Lime Down Solar Park

**Planning Inspectorate Reference:
EN010168**

**Wiltshire Council Comments on Submissions
Received at Deadline 2**

Deadline 3 (15 June 2026)

Key

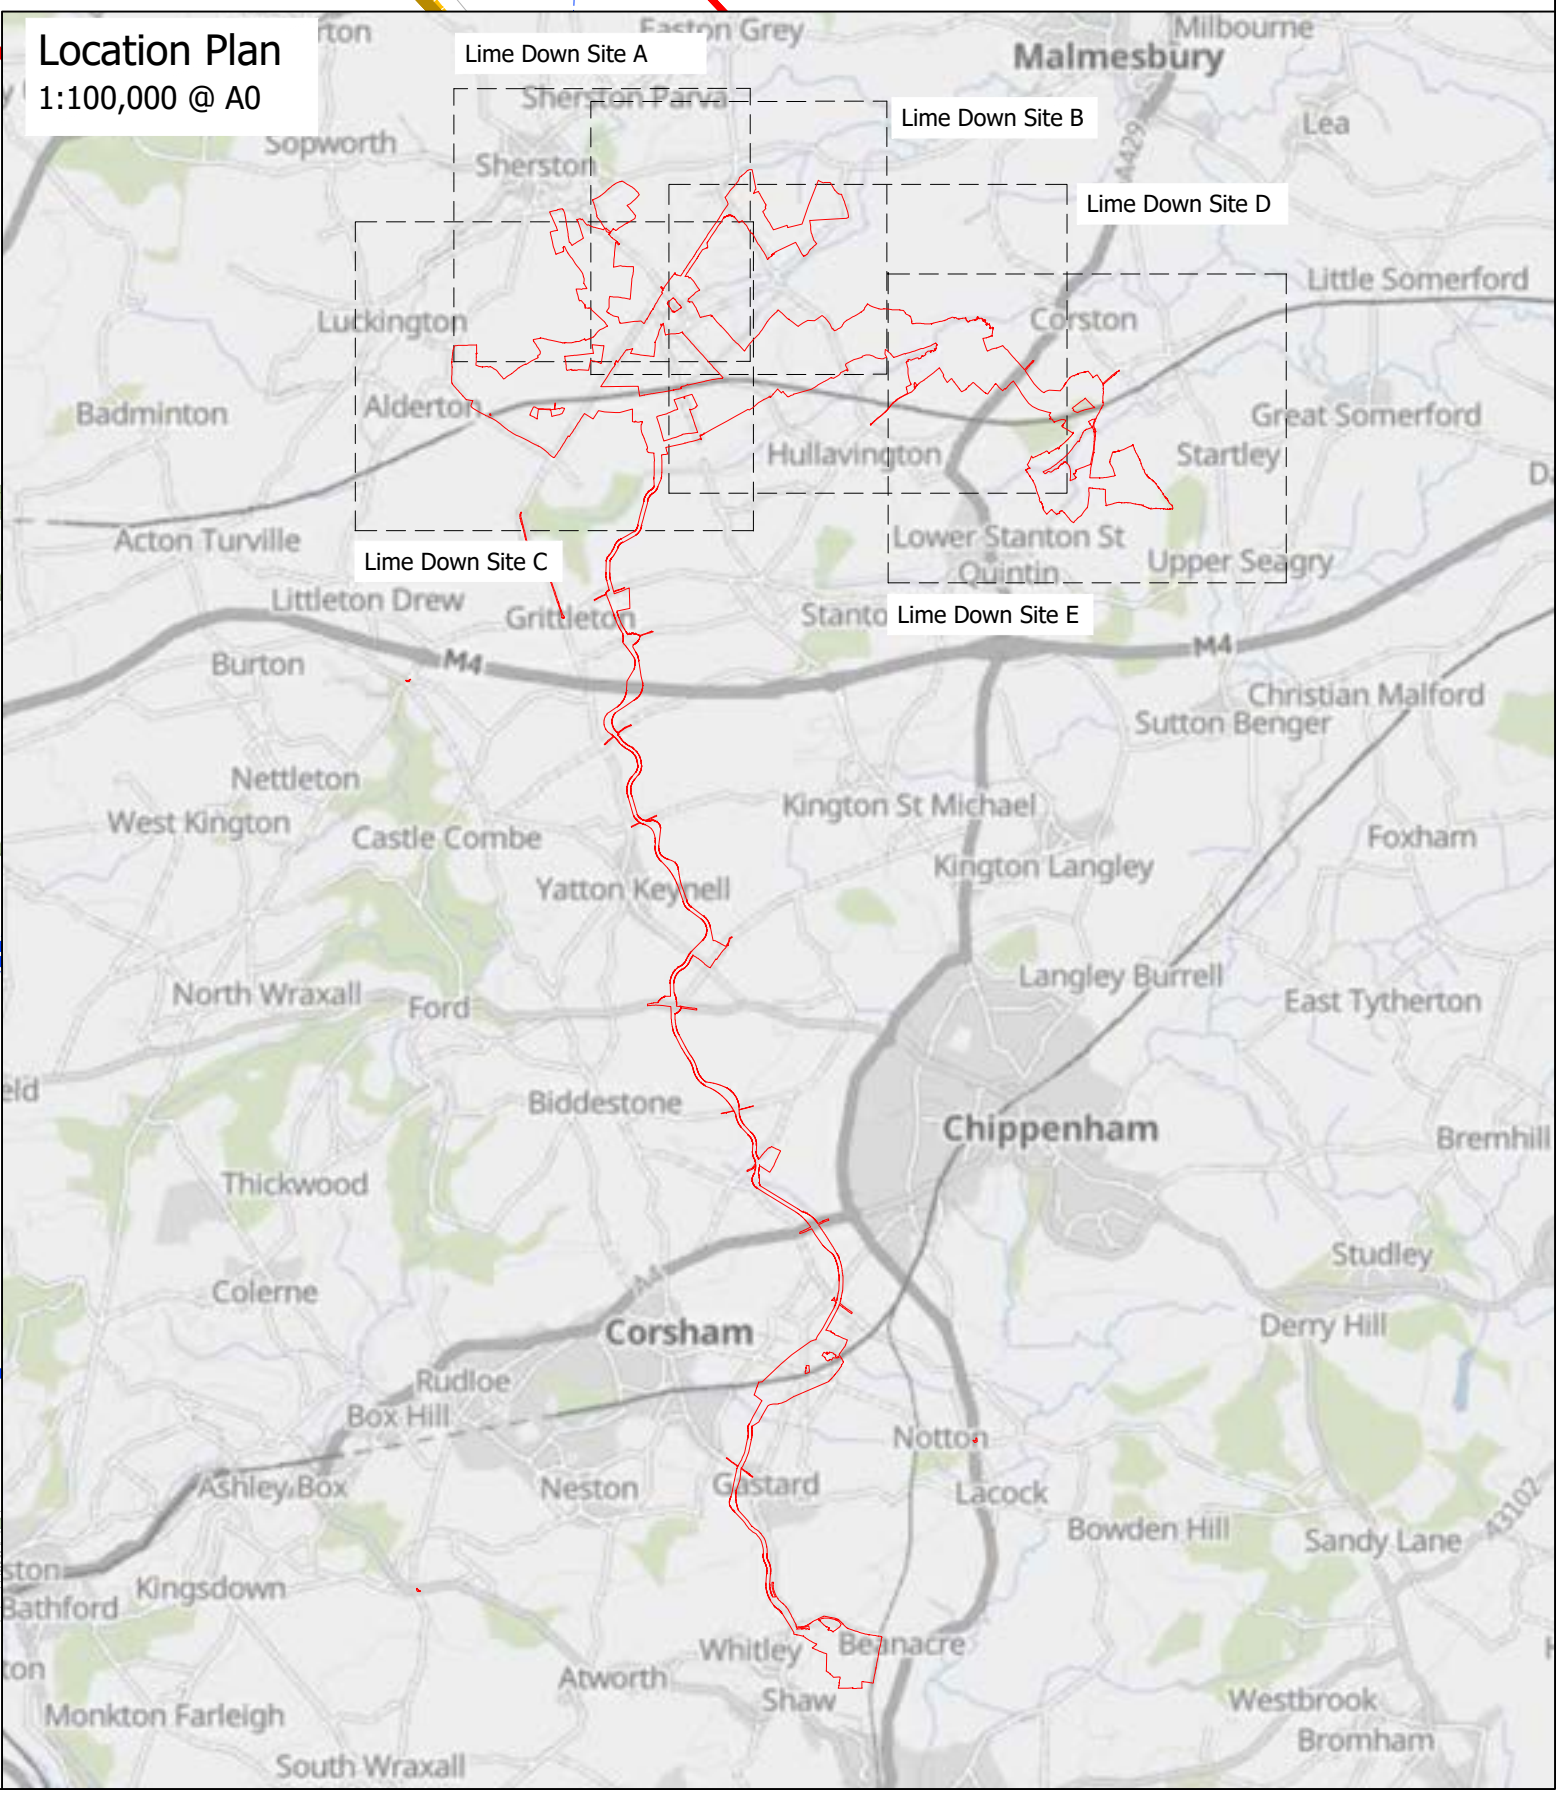
- 4.39. The Outline Landscape and Ecological Management Plan and ES Figure 3-4 must contain a table of species of tree, size, quantity and location to be provided for mitigated planting within the solar sites post completion of construction. The detail of mitigated planting for the removal of Category U and Category C trees must also be included within the design for replanting.
